Rocky Top Resources  
 Transportation Memorandum  
 (LSC #194630)  
 August 23, 2019

<sup>1</sup> Add PCD File No. PPR1913

RE: Rocky Top Resources  
El Paso County, CO  
Transportation Memorandum  
LSC #194630

# Existing Traffic, Lane Geometry, Traffic Control and Level of Service

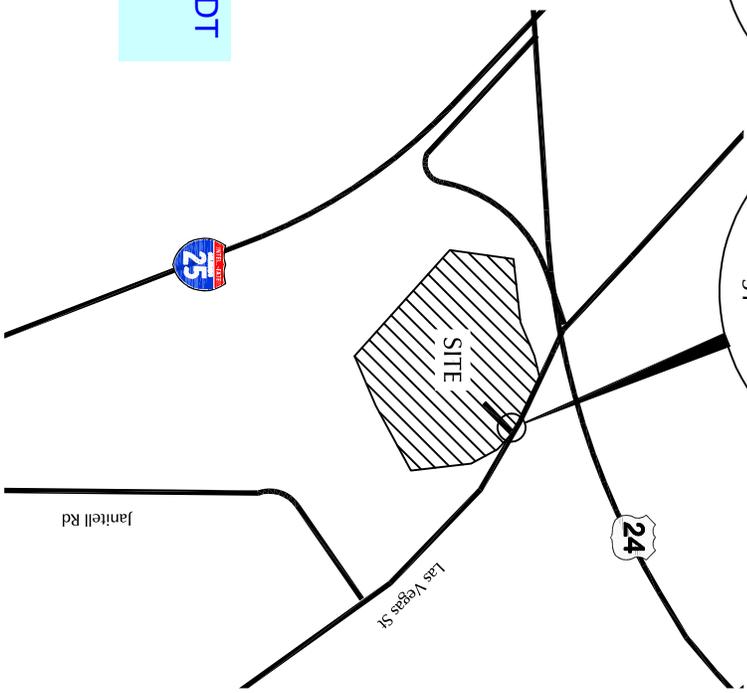
Number: 2 Author: Daniel Torres Subject: Callout Date: 9/25/2019 10:15:19 AM  
[it appears that this may be a typo. Please revise.](#)

Number: 3 Author: Daniel Torres Subject: Text Box Date: 9/25/2019 10:15:20 AM  
[Provide ADT](#)

Author: cguillotte Subject: Sticky Note Date: 10/7/2019 10:01:37 AM  
LSC Response: This has been corrected

Author: cguillotte Subject: Sticky Note Date: 10/7/2019 10:01:55 AM  
LSC Response: ADT has been added
